Our Ref: R/2025/15/C  
File No: 2026/242780  
Your Ref: SSD-93222706

**Advice on EIS – Waterloo Estate (South) Concept – SSD-93222706**

Thank you for your correspondence, dated 4 May 2026, inviting the City of Sydney Council (the City) to comment on SSD-93222706 for the concept approval for the staged redevelopment of Waterloo Estate (South), supported by a concurrent rezoning to modify Sydney Local Environmental Plan 2012 (SLEP 2012) and the Waterloo Estate (South) Design Guide (Design Guide).

Drawing Name
Block 4
Proposed Envelope -
Plan

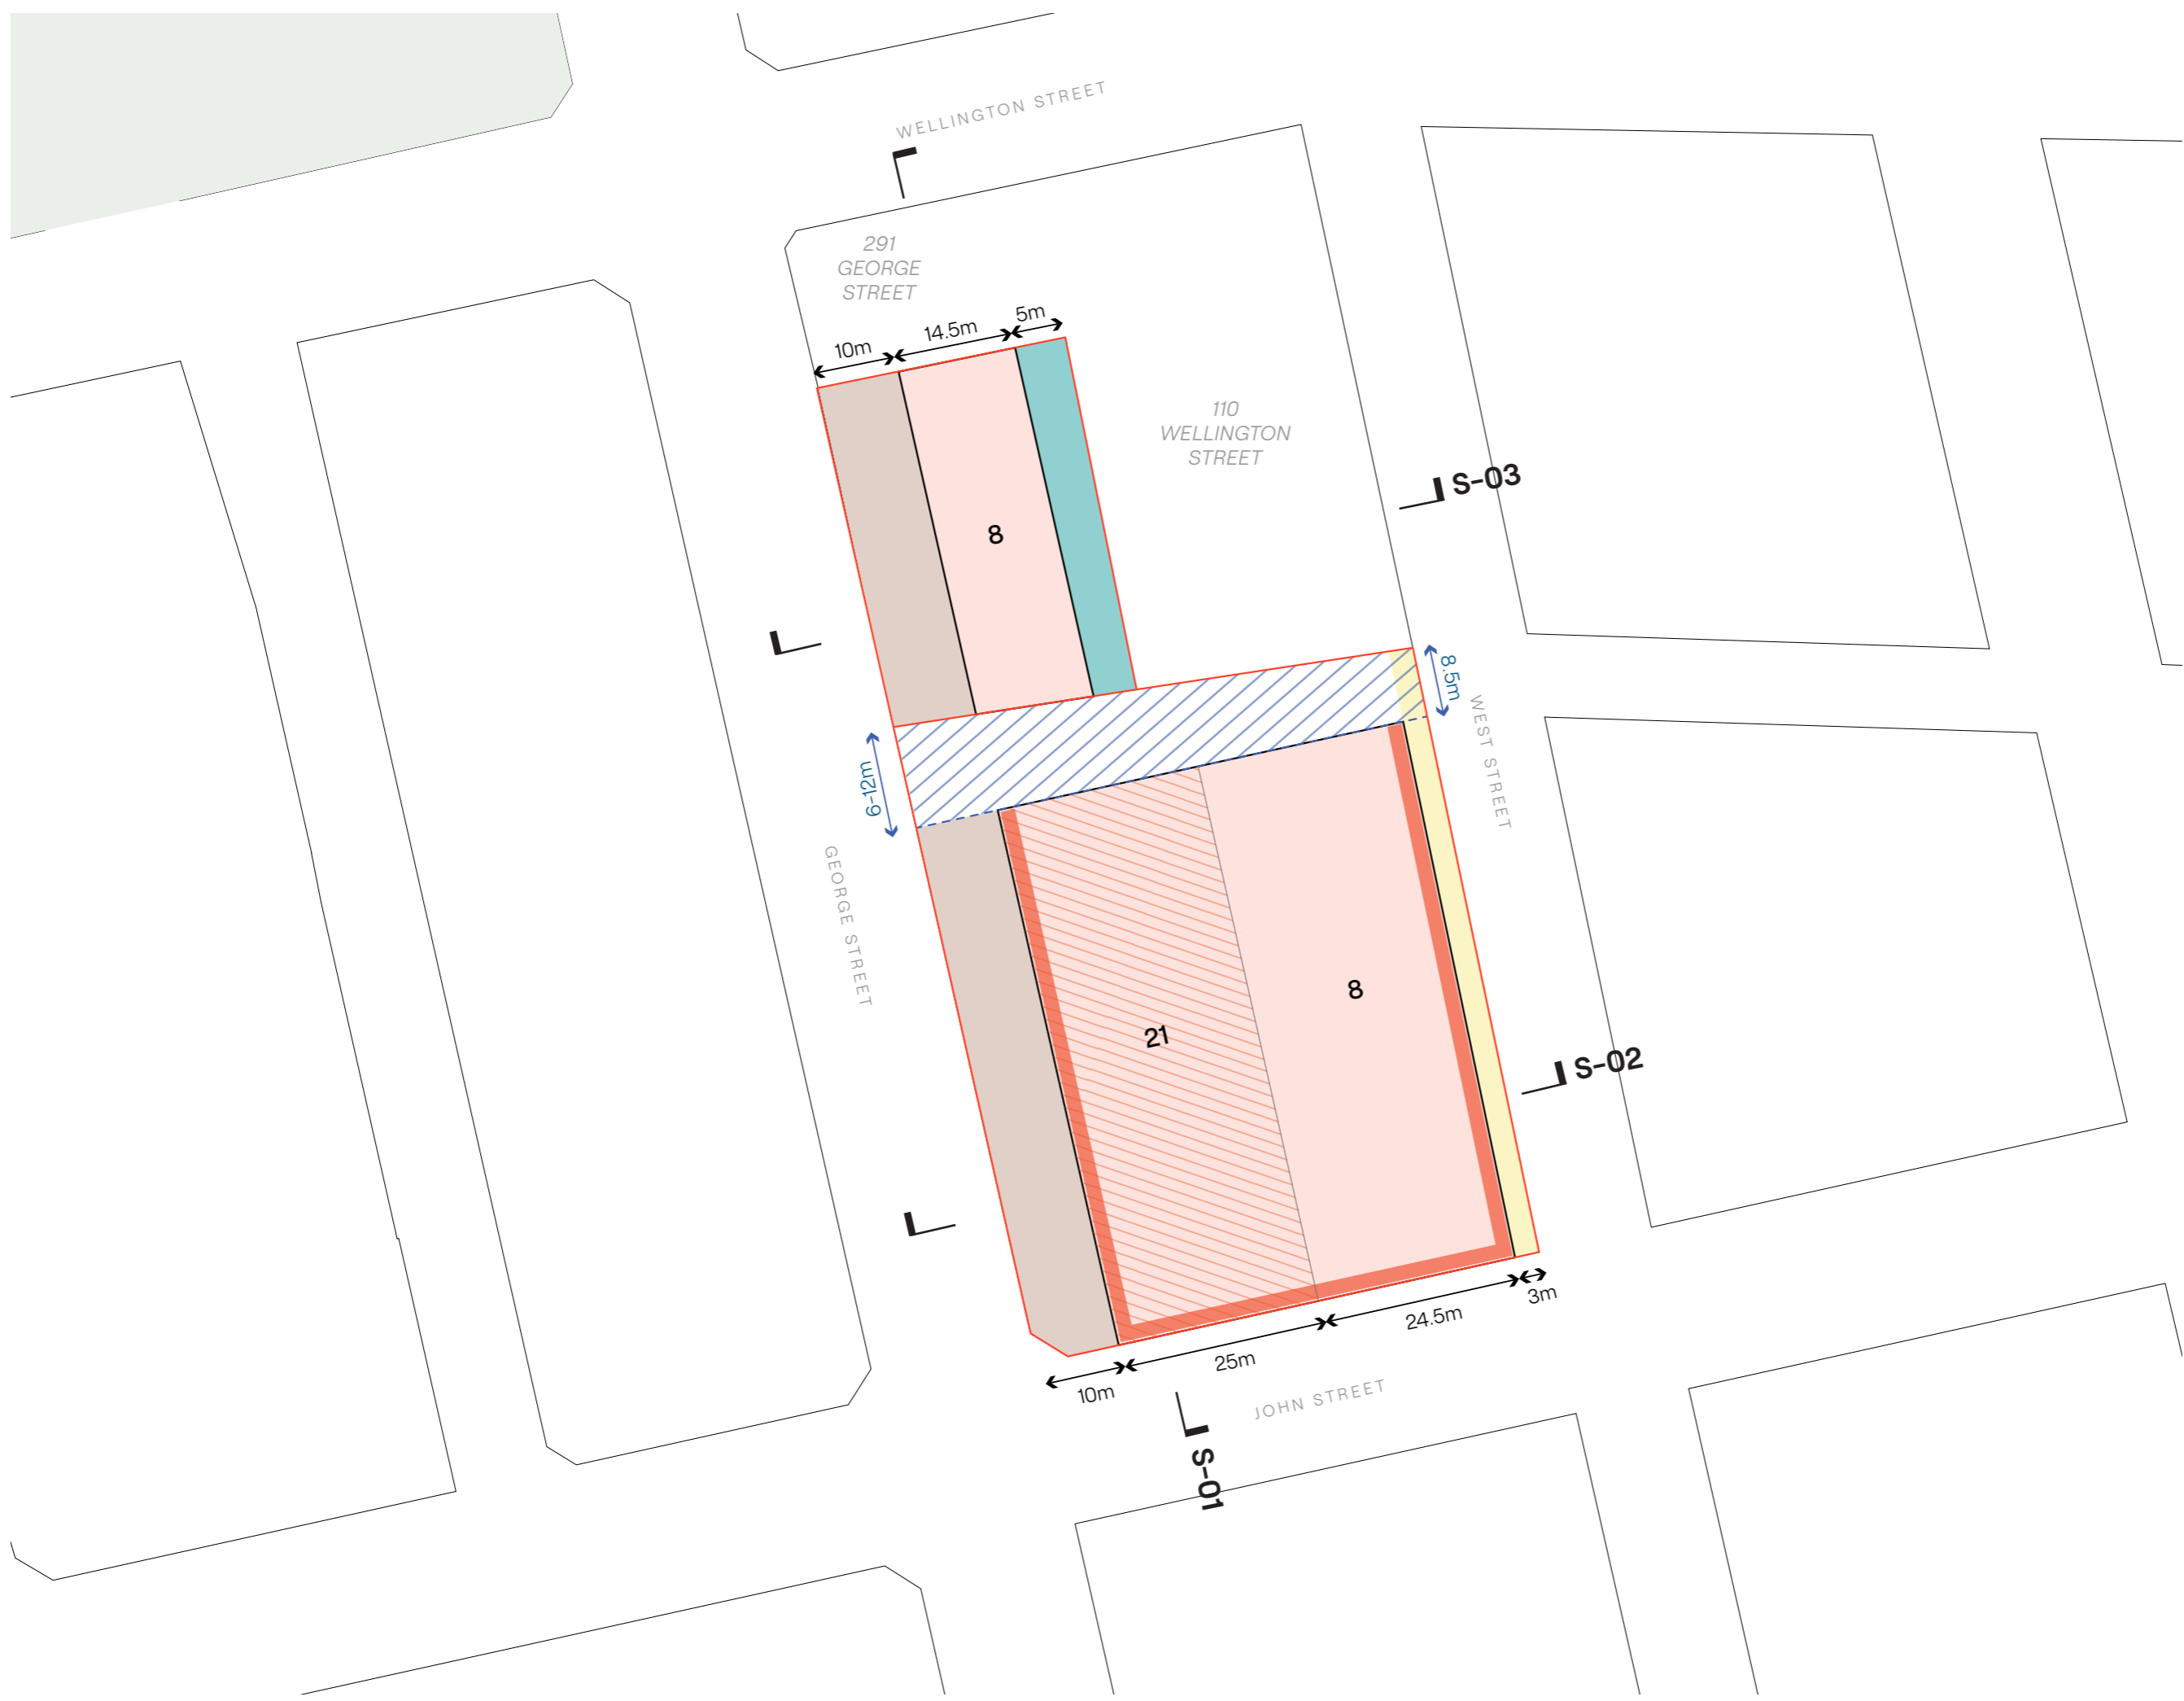
| Block | Proposed LEP height control | Reference scheme height | Recommendation                                                                                                                                                           |
|-------|-----------------------------|-------------------------|--------------------------------------------------------------------------------------------------------------------------------------------------------------------------|
| 4C    | 74m                         | 30m                     | The eastern part of the site fronting West Street is too high. The height control should be split down the middle and a lower control put over the eastern half.         |

Drawing Name
Blocks 5 & 6
 Proposed Envelope -
 Plan

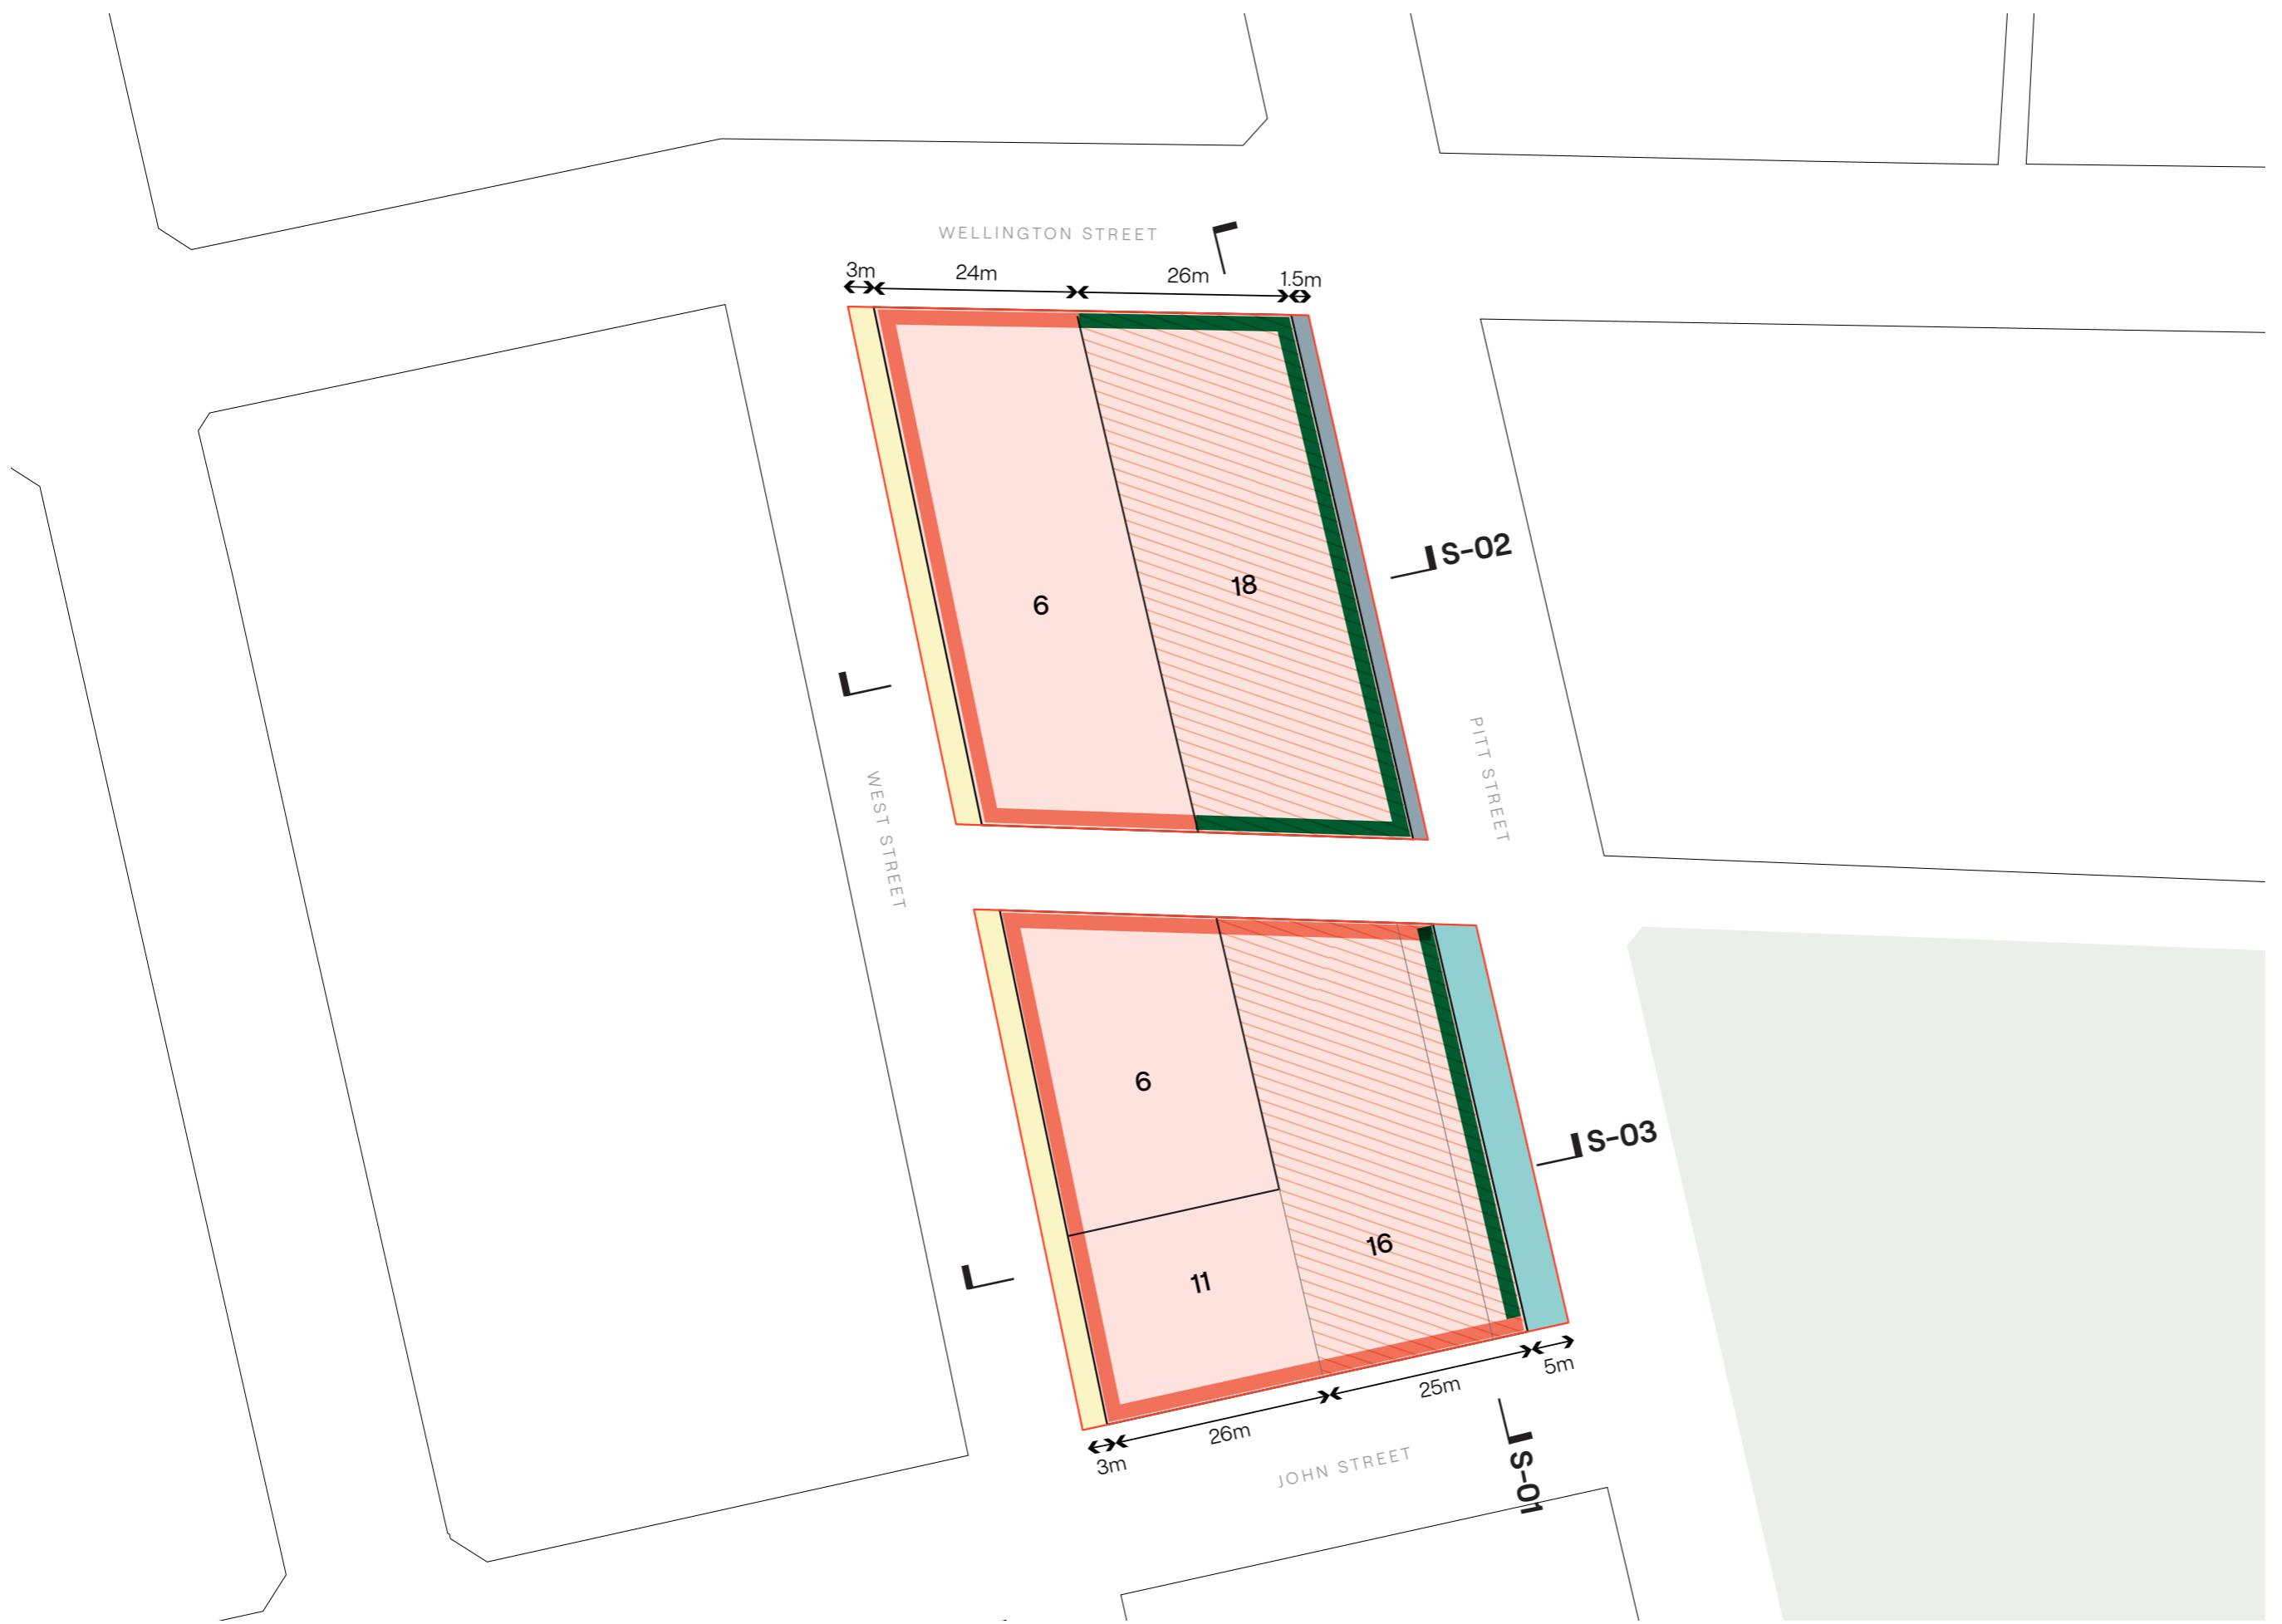
| Block | Proposed LEP height control | Reference scheme height | Recommendation                                                                                                                                                           |
|-------|-----------------------------|-------------------------|--------------------------------------------------------------------------------------------------------------------------------------------------------------------------|
| 5A    | 65m                         | 25m/62m                 | The north and western parts are significantly too high and should be split off from the higher component. The control for the higher component should be reduced to 63m. |
| 6A    | 62m                         | 24m/40m                 | The western part of the block should have a lower height control(s) to reflect the significantly lower proposed form.                                                    |
